From: Anita Gardner
Sent: 03 July 2019 10:18
To: Planning.Responses
Subject: FW: Applications AB/48/19/PL and AB/49/19/L
Attachments: A6001-03A - Site Plan.pdf; A6001-05A - Existing and Proposed Sparks Yard Level Ground Floor Plan.pdf; A6001-06A - Existing and Proposed Sparks Yard Level First Floor Plan.pdf; A6001-08A - Existing and Proposed Cross Sections.pdf

Further to our email of 27th June I write in order to submit the following revised drawings:

Sparks Yard,
18 Tarrant Street
Arundel, West Sussex,
BN18 9DJ,
United Kingdom

A6001-08A

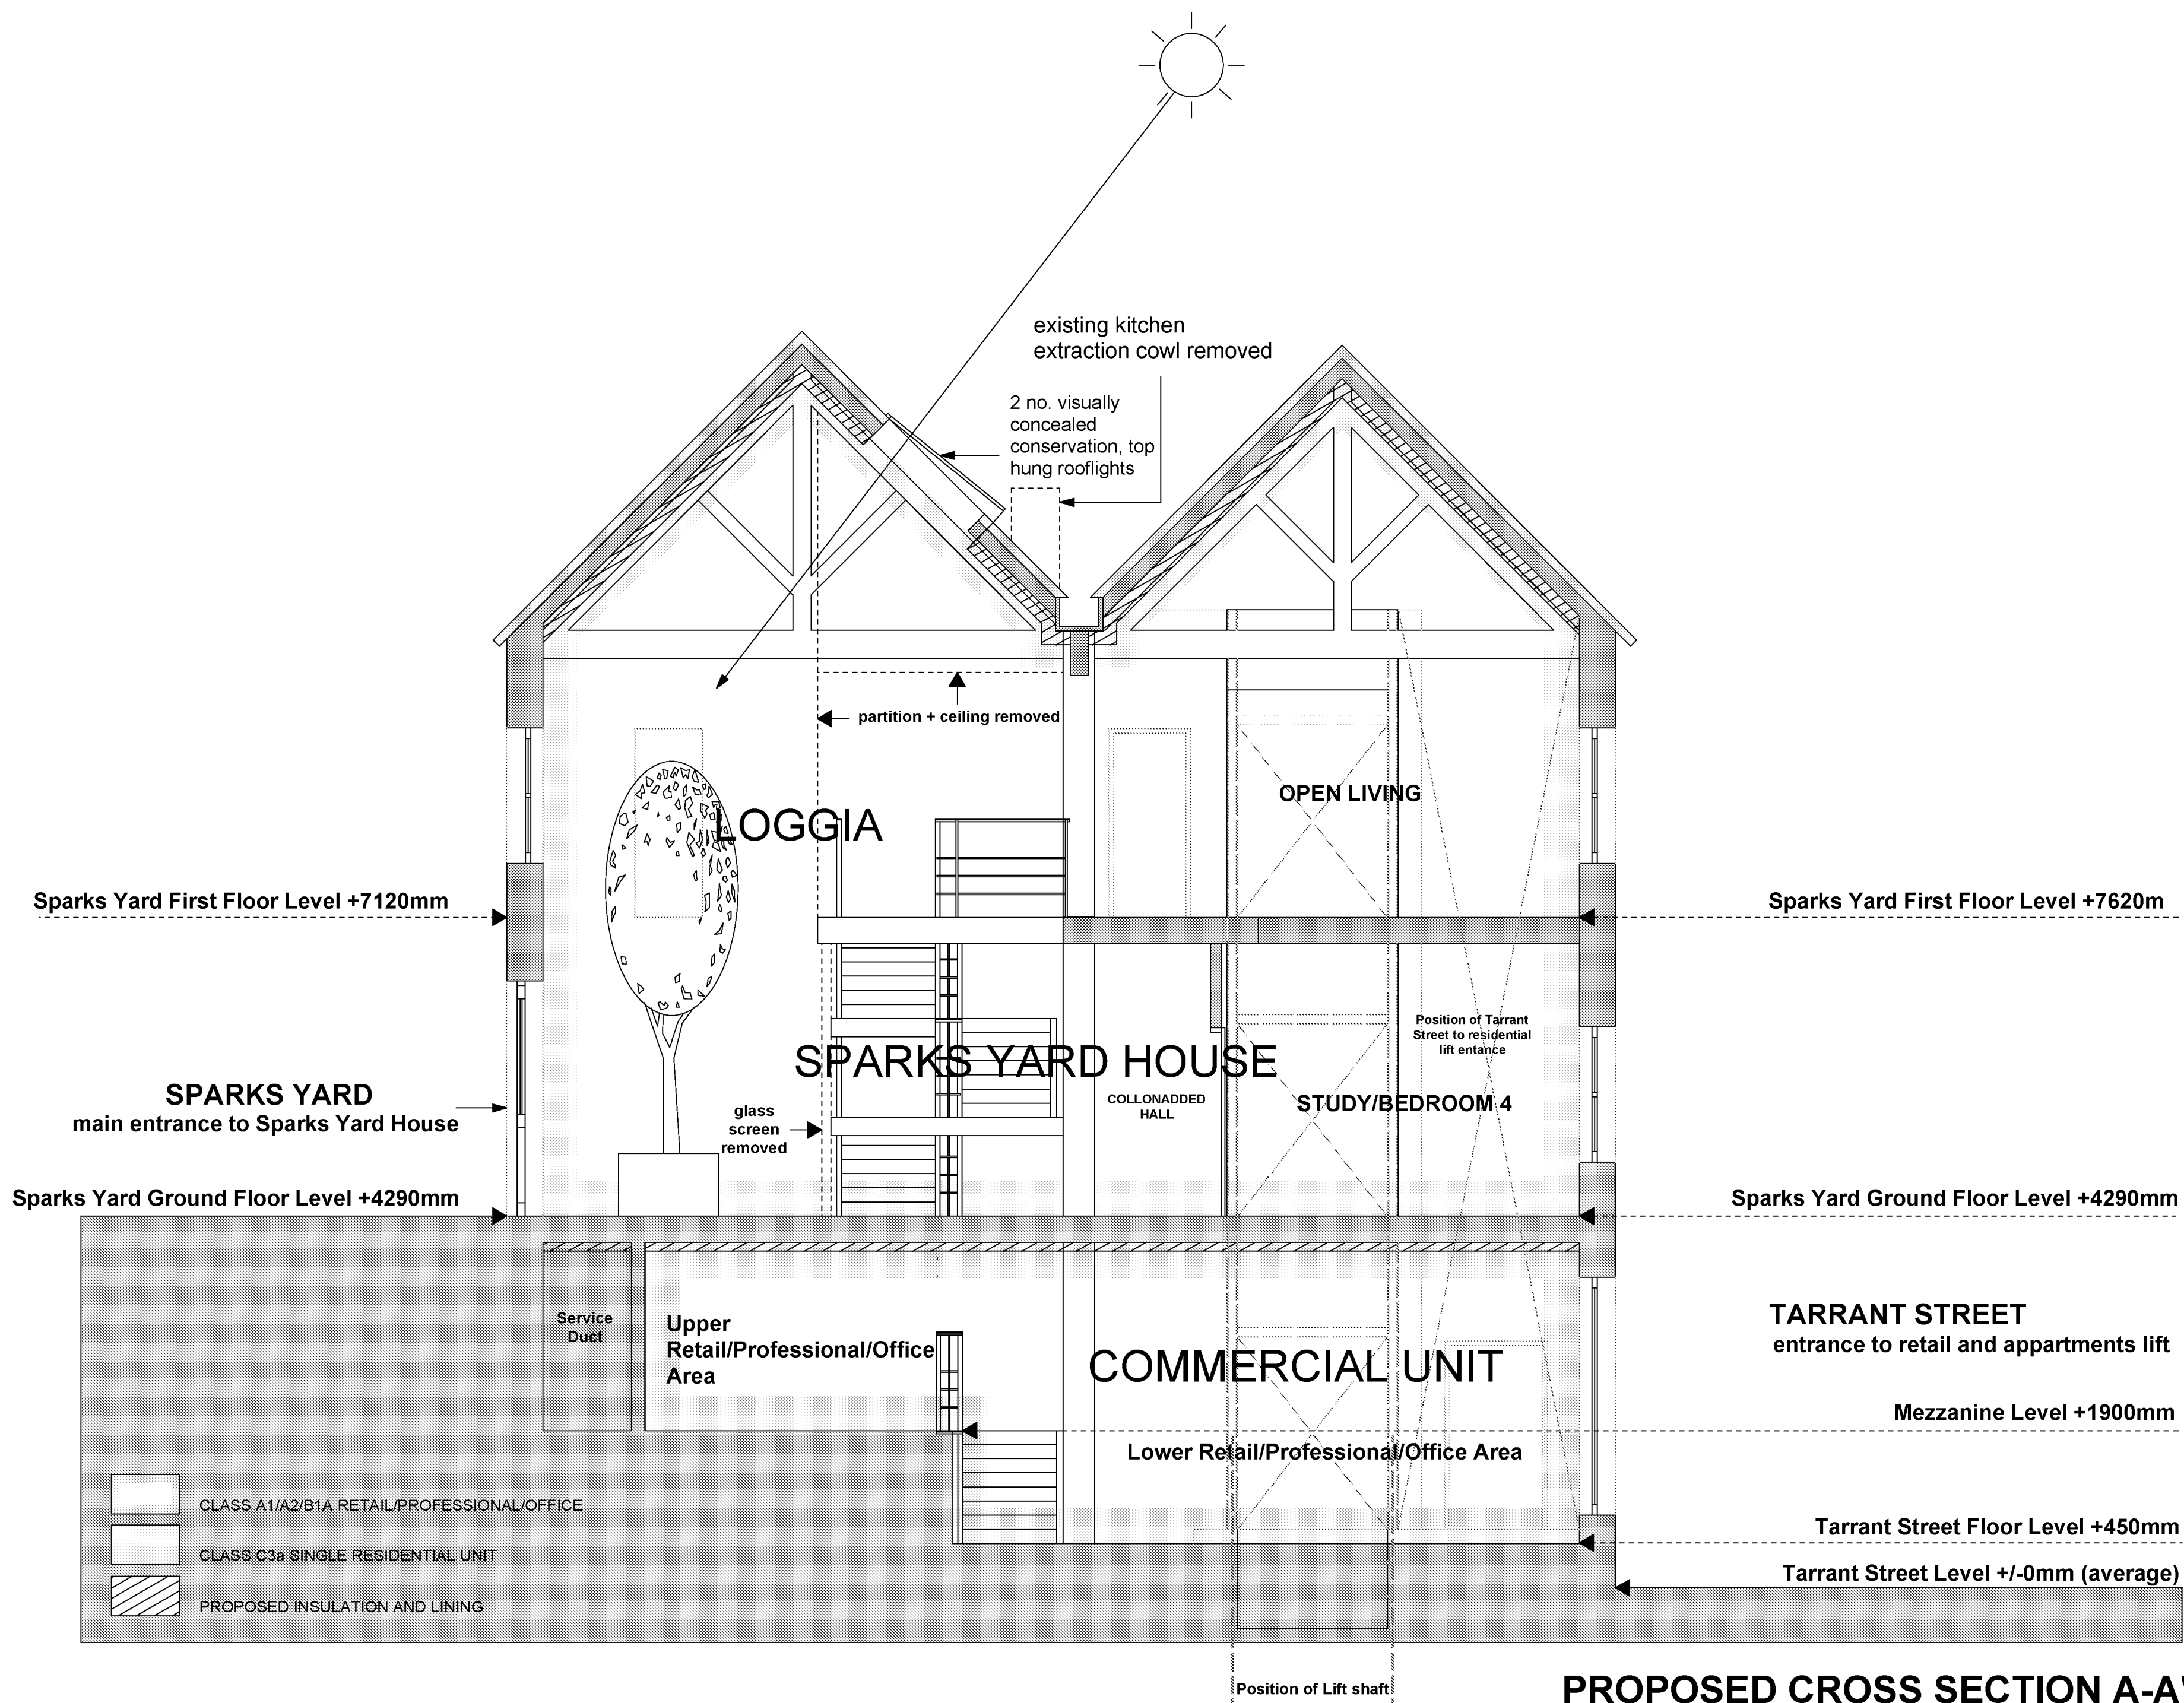
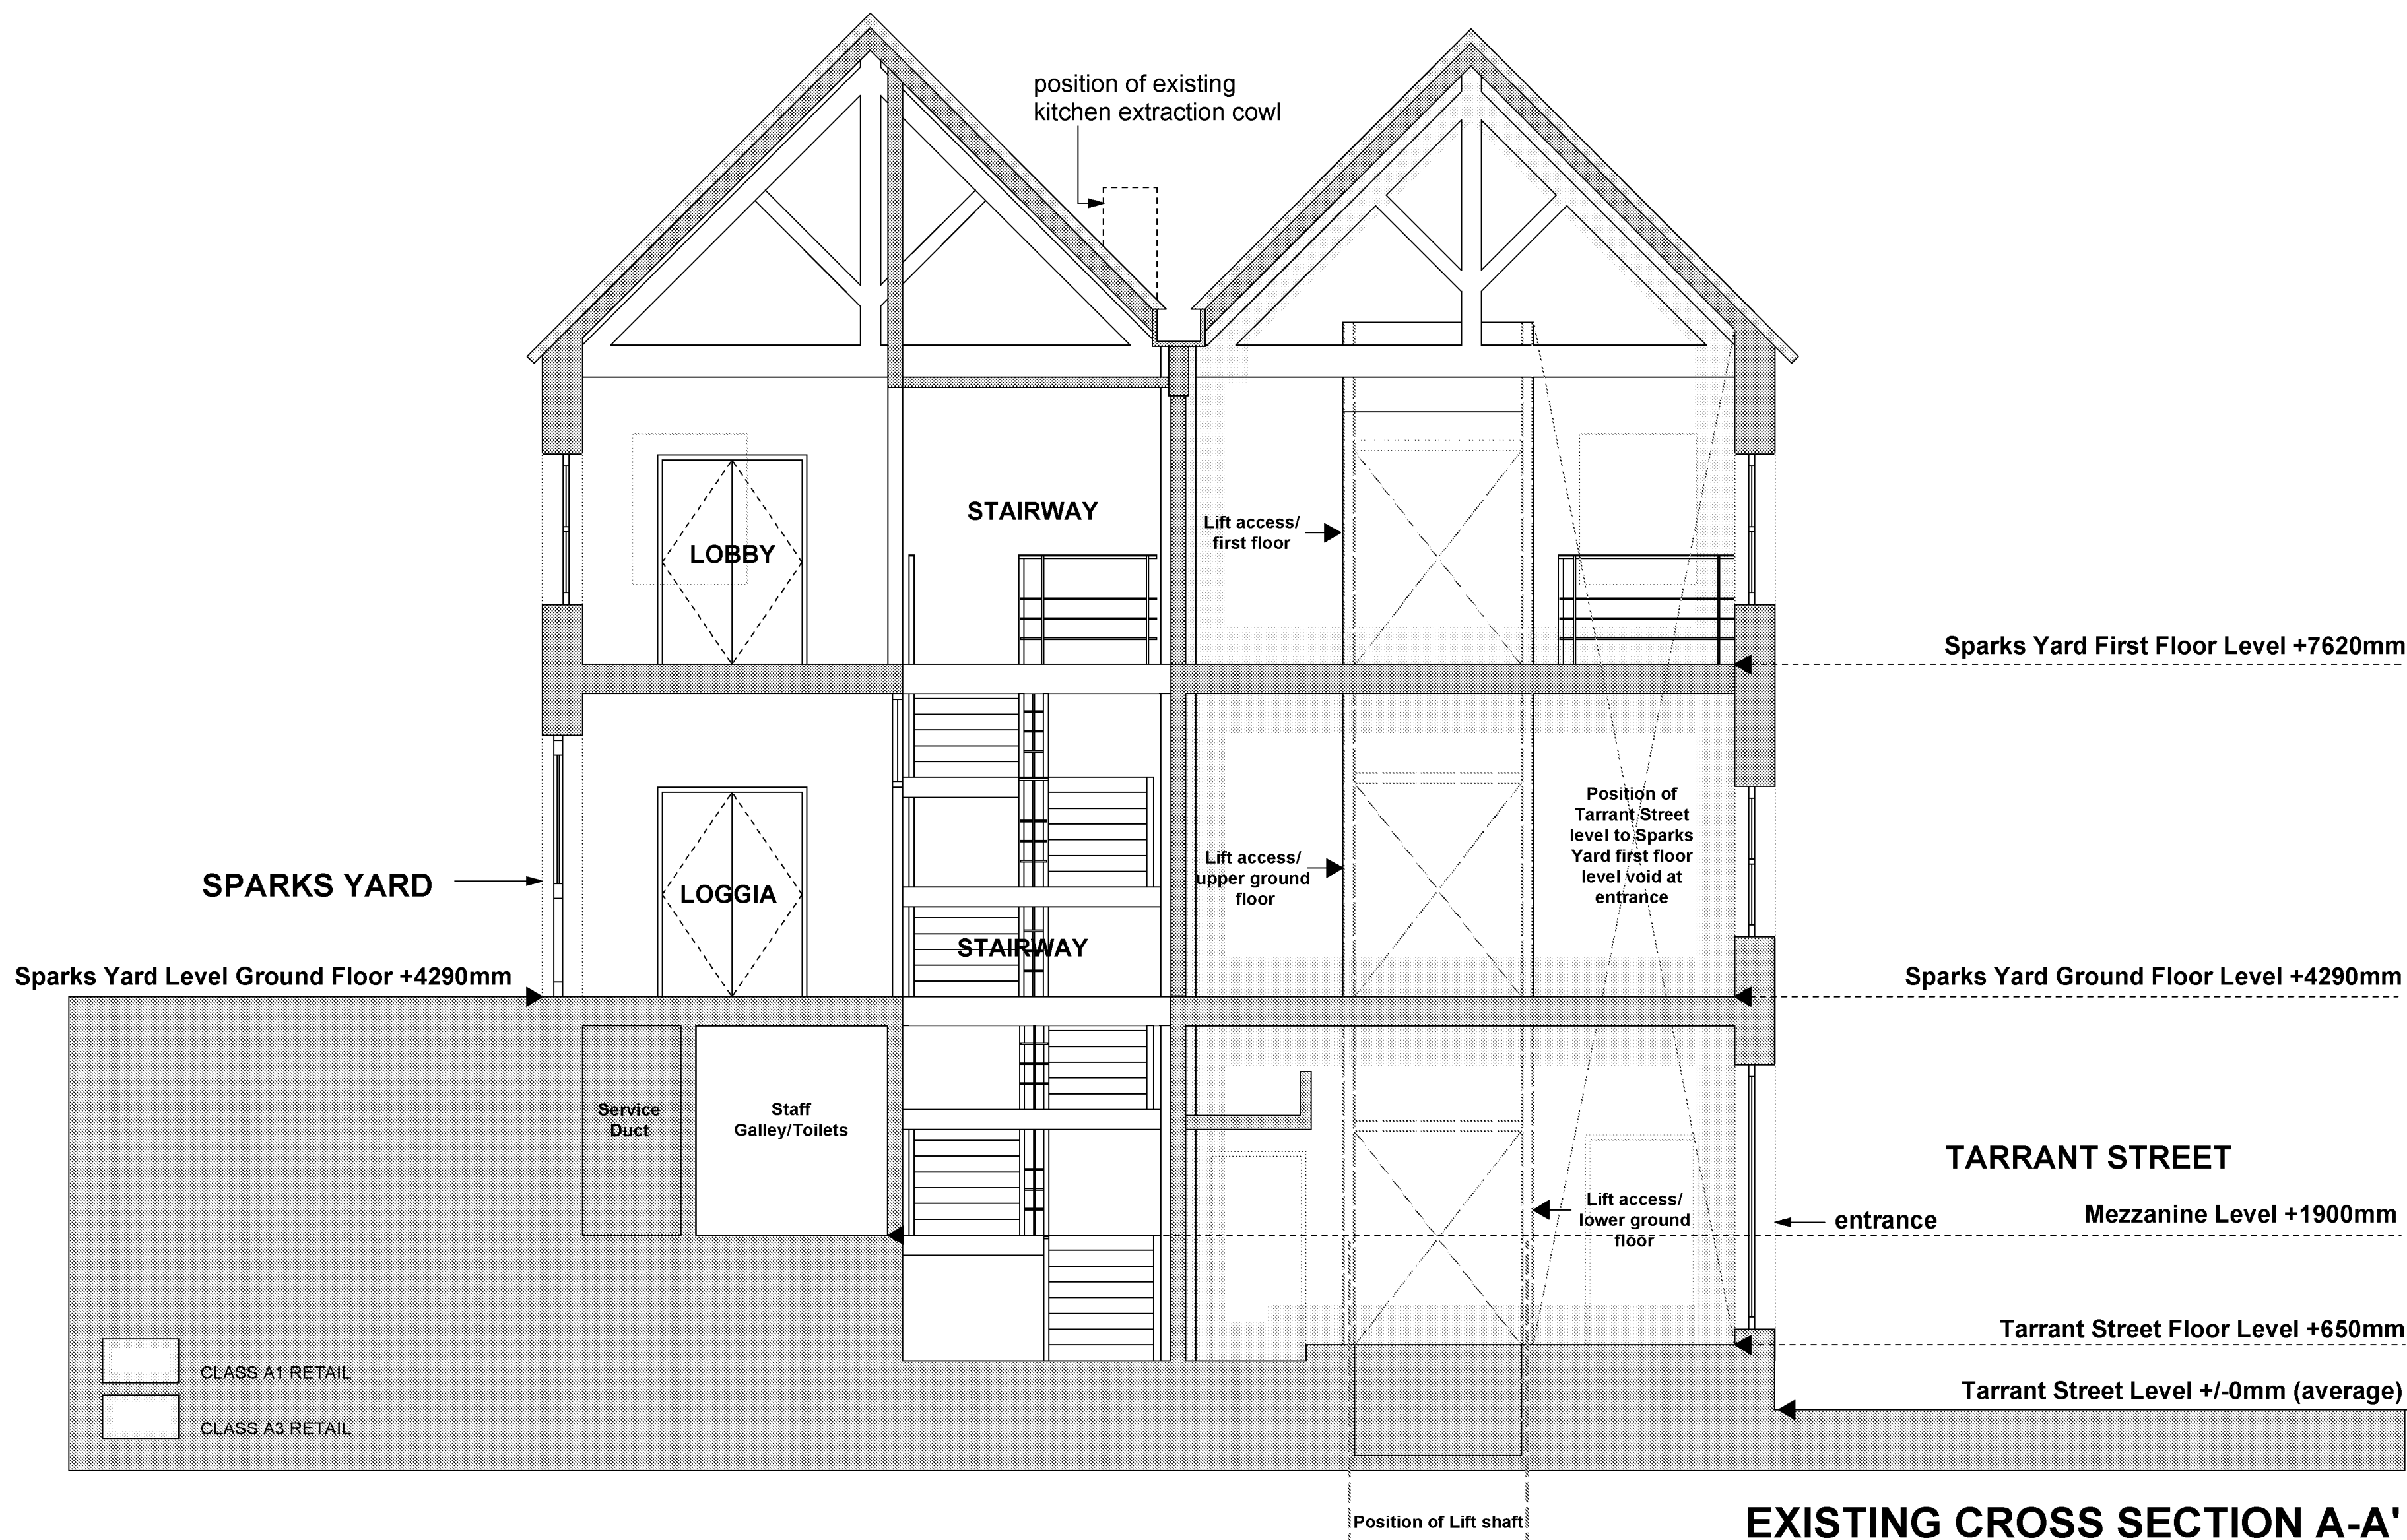
Drawings A6002 -05 Revision A, -06 Revision A and -08 Revision A.

All three drawings are revised, removing the previously proposed plasterboard faced, insulated internal wall linings to the upper two floors of the building.

A6001-03A

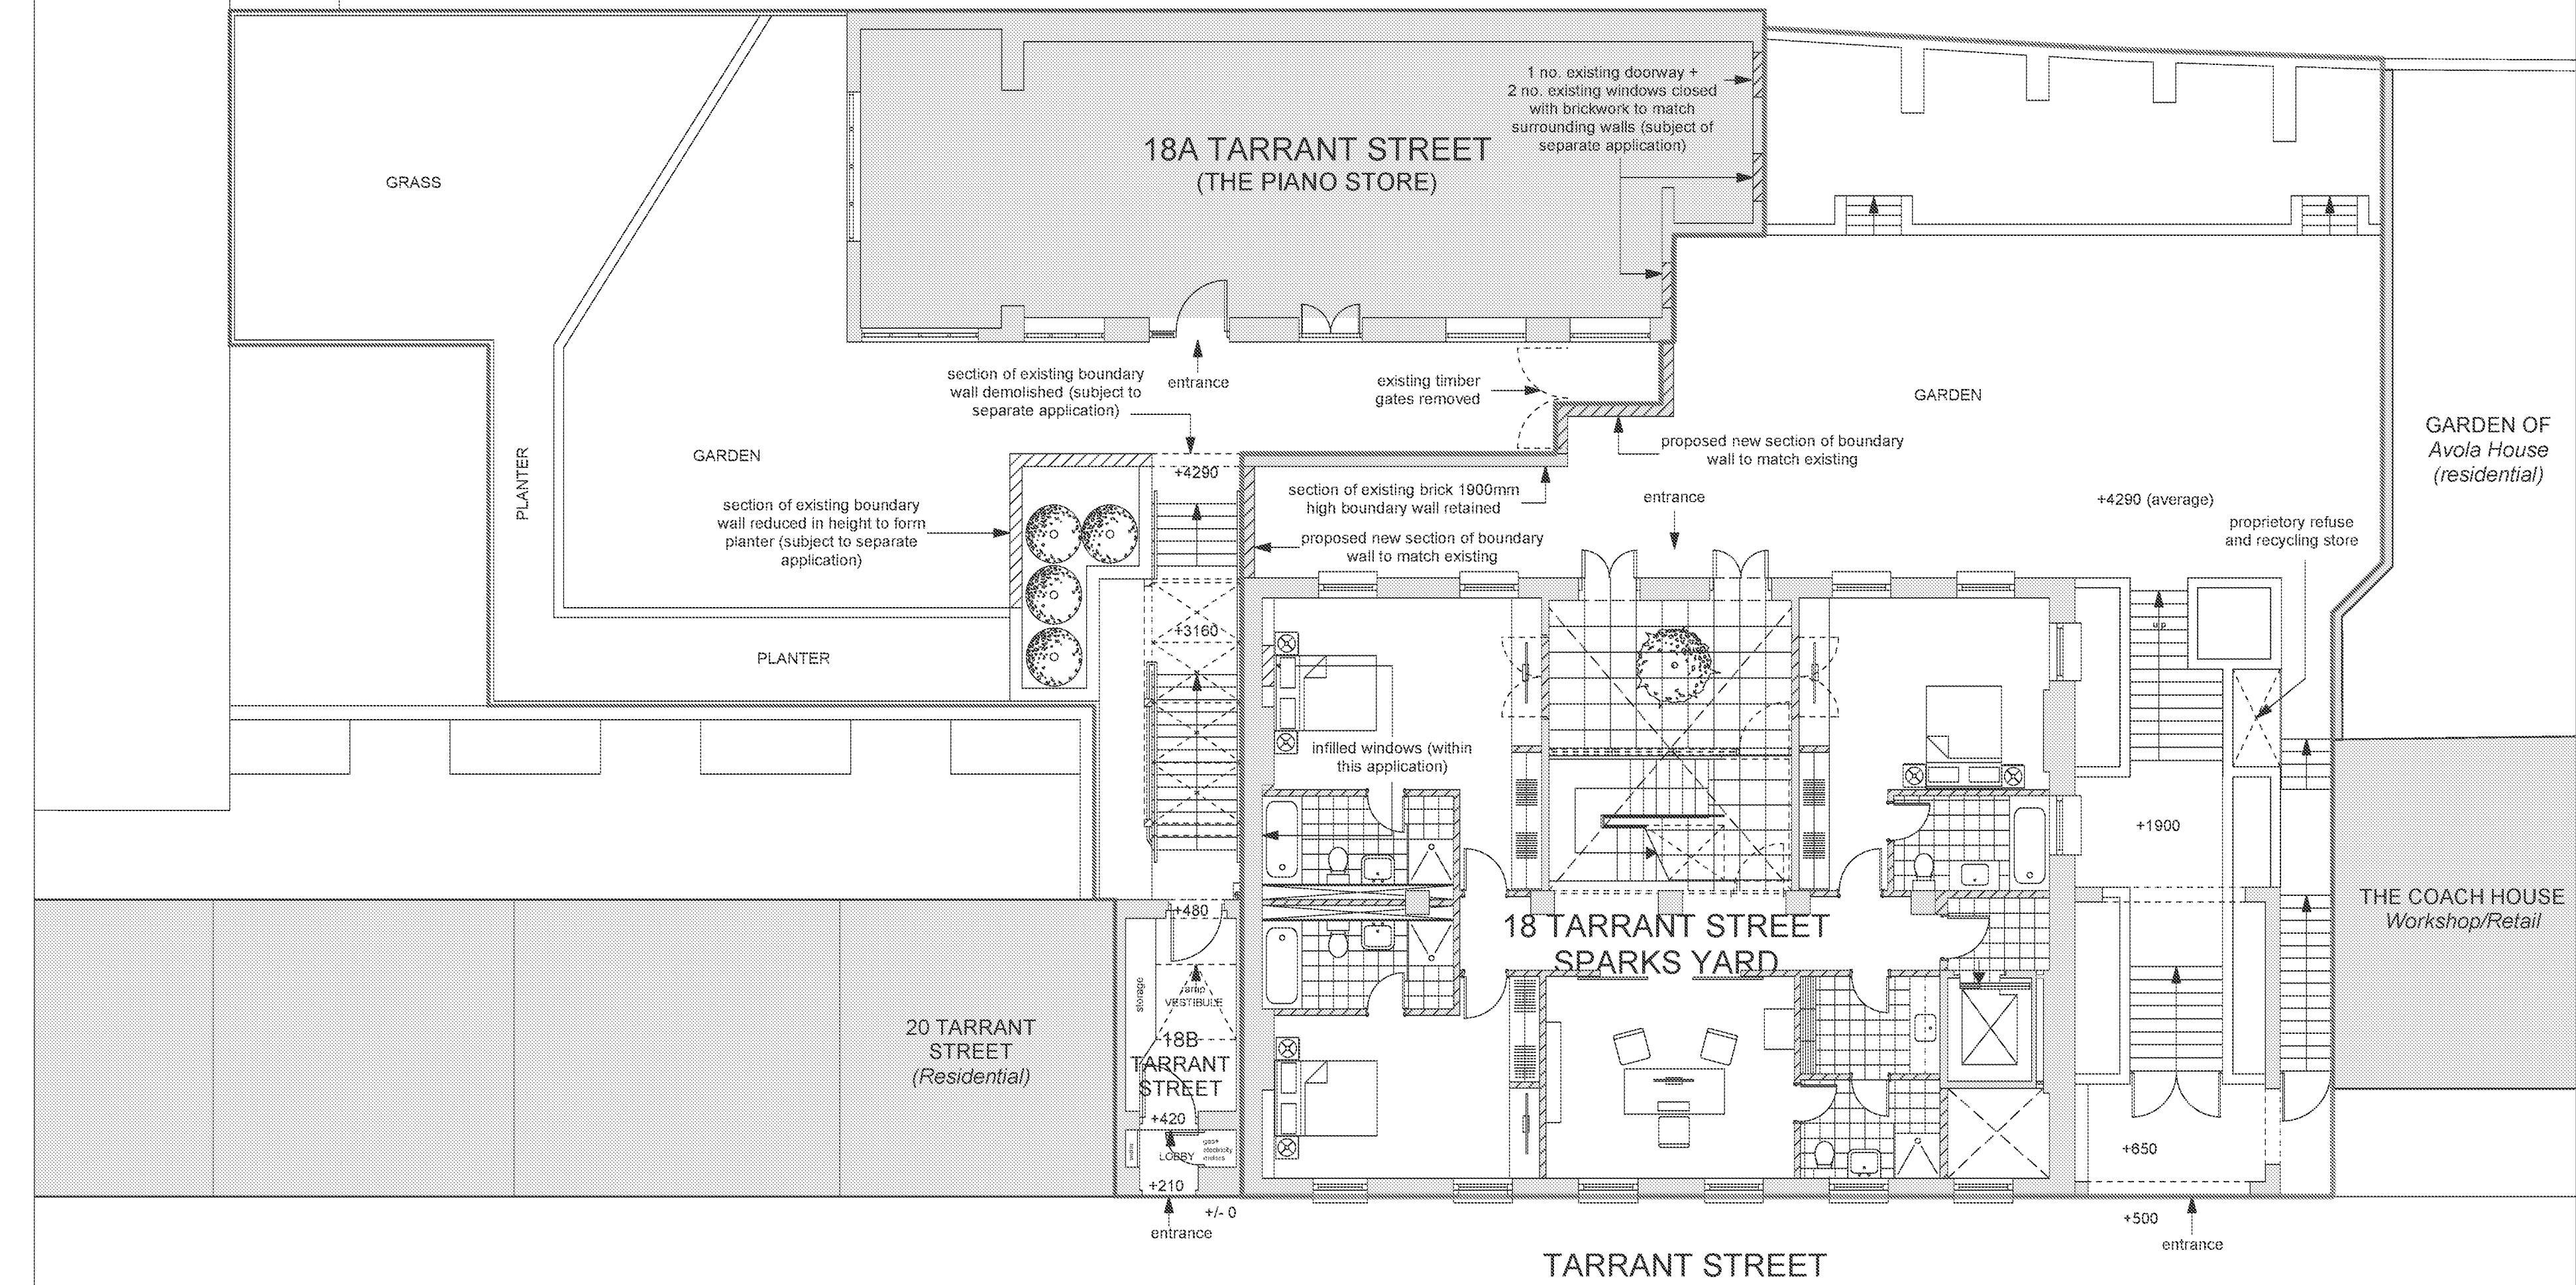
Drawing A6002-03 Revision A

This drawing is revised to show further information/clarification regarding the proposed revisions to the existing boundary wall between the application site and the adjacent 18A Tarrant Street.
